EPC STORMWATER REVIEW COMMENTS
IN ORANGE BOXES WITH BLACK TEXT

UDON SOUTH SITE DEVELOPMENT PLAN 12265 HIGHWAY 94

POND PLAN
 SHEET 9 OF 20

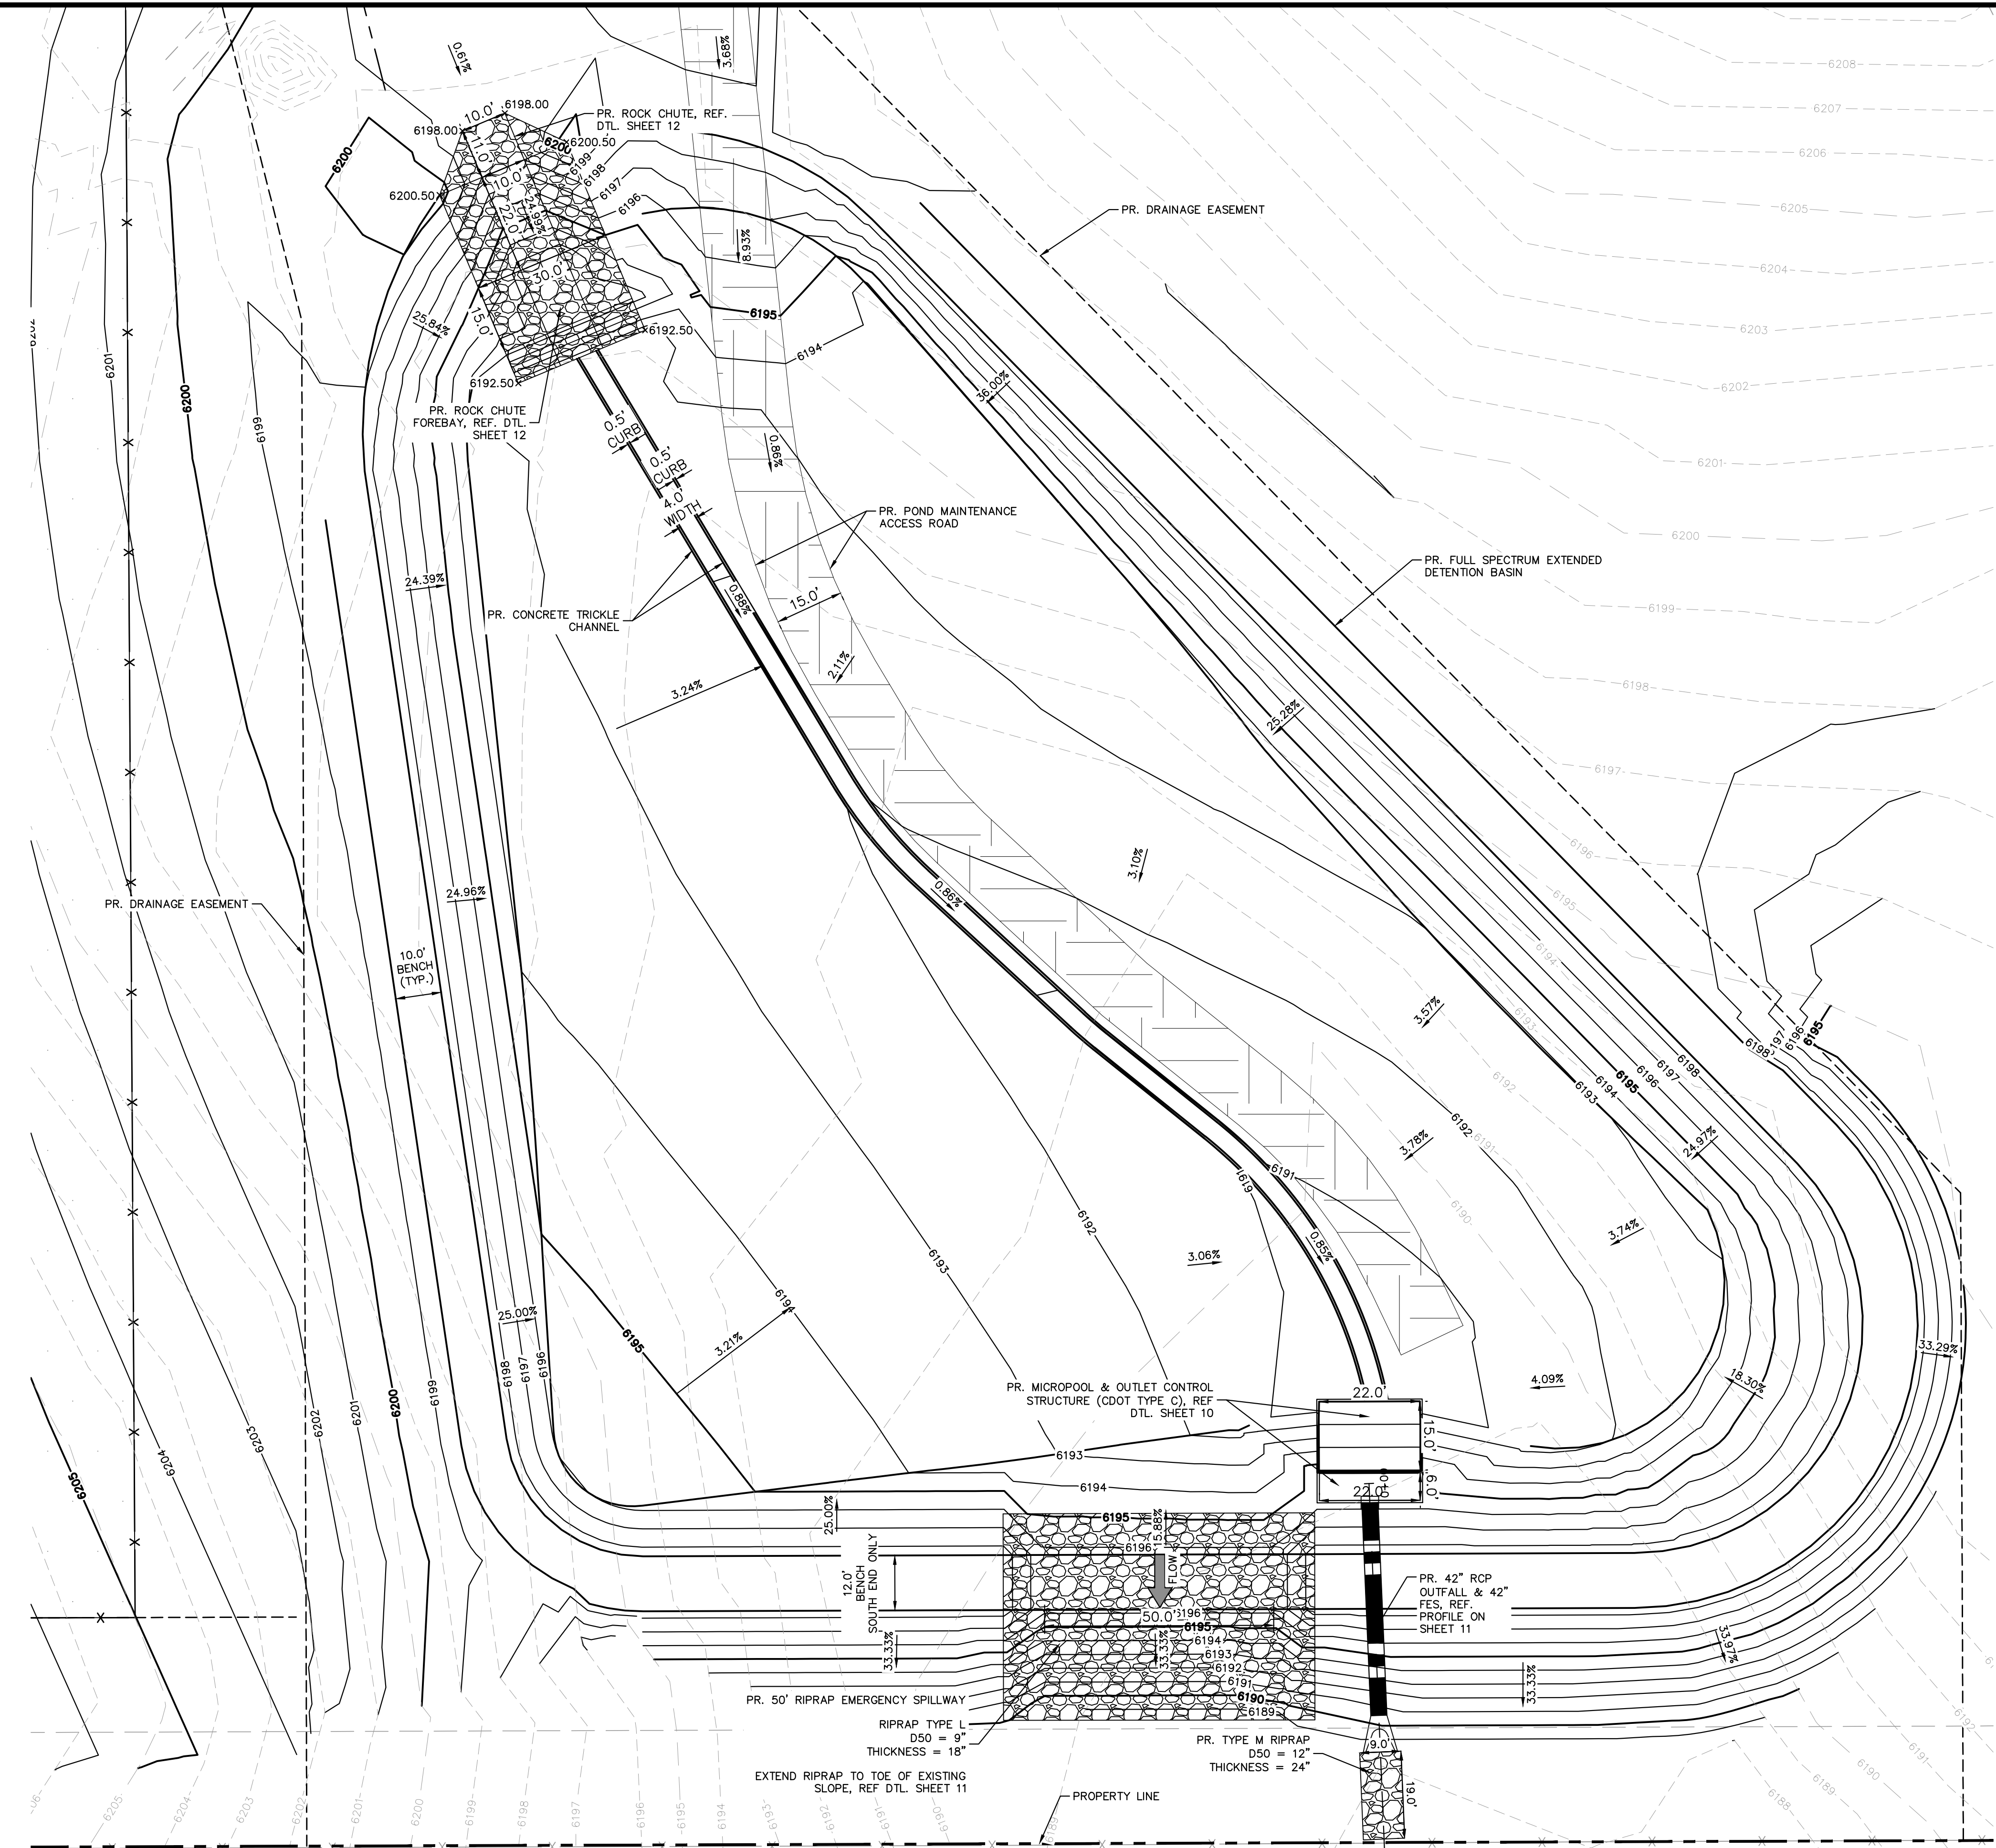
Since this pond isn't deeper than 10ft and doesn't meet other jurisdictional dam minimum criteria, submit Proof of Submittal for a State Non-Jurisdictional Water Impoundment Structure Notification.

level spreader to be installed. Provide design detail. This is now concentrated flow and point discharge. Update FDR

Typical Comment: Assign a name/number to all PBMPs and then update all submitted text and drawings accordingly with consistent labeling throughout (example: "Pond A" or "Pond 1").

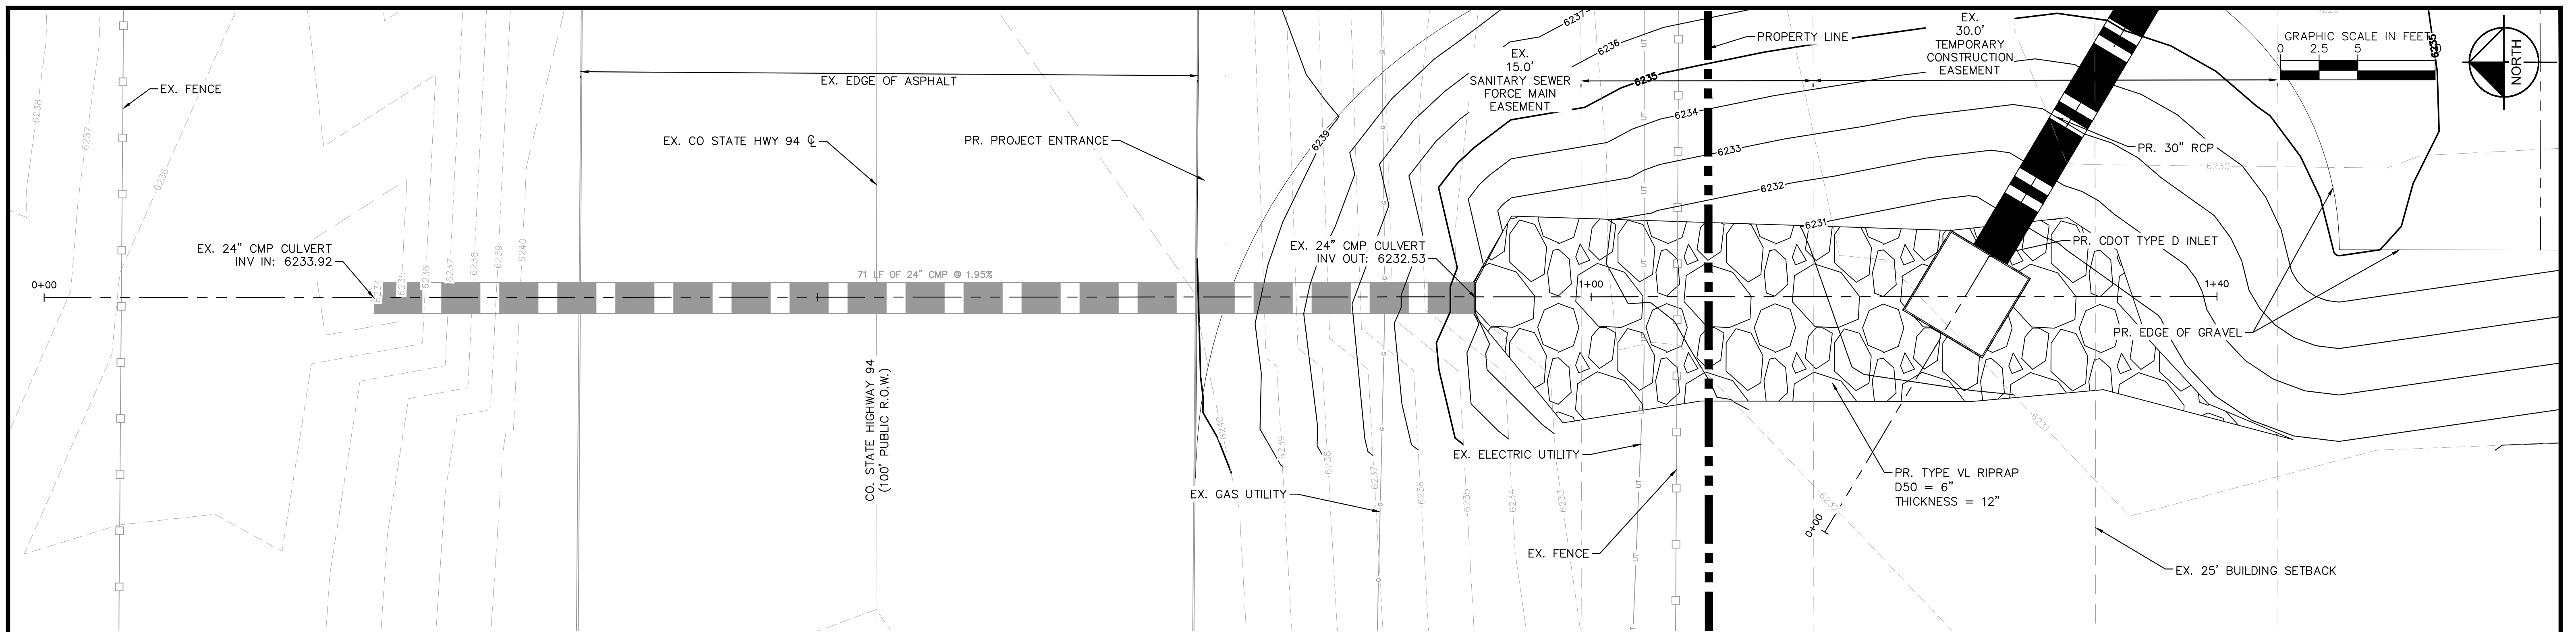
Where is the proposed grade in this interface? Clarify how this works and maintains a pond bottom slope of 3% to the top of the trickle channel.

These details do not match, please revise to remove discrepancy.

Adding a detail that shows the transition from forebay to trickle channel would be really helpful. Also, it would help to add a note and/or linework that shows the pond bottom throughout each detail here.

Pond bottom should meet the top of trickle channel to avoid erosion problems. We commonly see issues where if the pond bottom isn't graded correctly, erosion will continue along the full length of the trickle channel and the flow bypasses the trickle channel.

The bottom of the forebay notch should be at the same elevation as the flow line of the trickle channel. But this detail shows the notch extending down below the flowline of the TC, such that the forebay would hold water. Please revise.

Bottom of pond has to be graded to the top of the trickle channel. Doing so on this detail will still create a transition that needs to be shown more clearly (per my comments on the last review). Make sure that the area just downstream of the forebay berm does not hold water (ie. drains to the trickle channel).
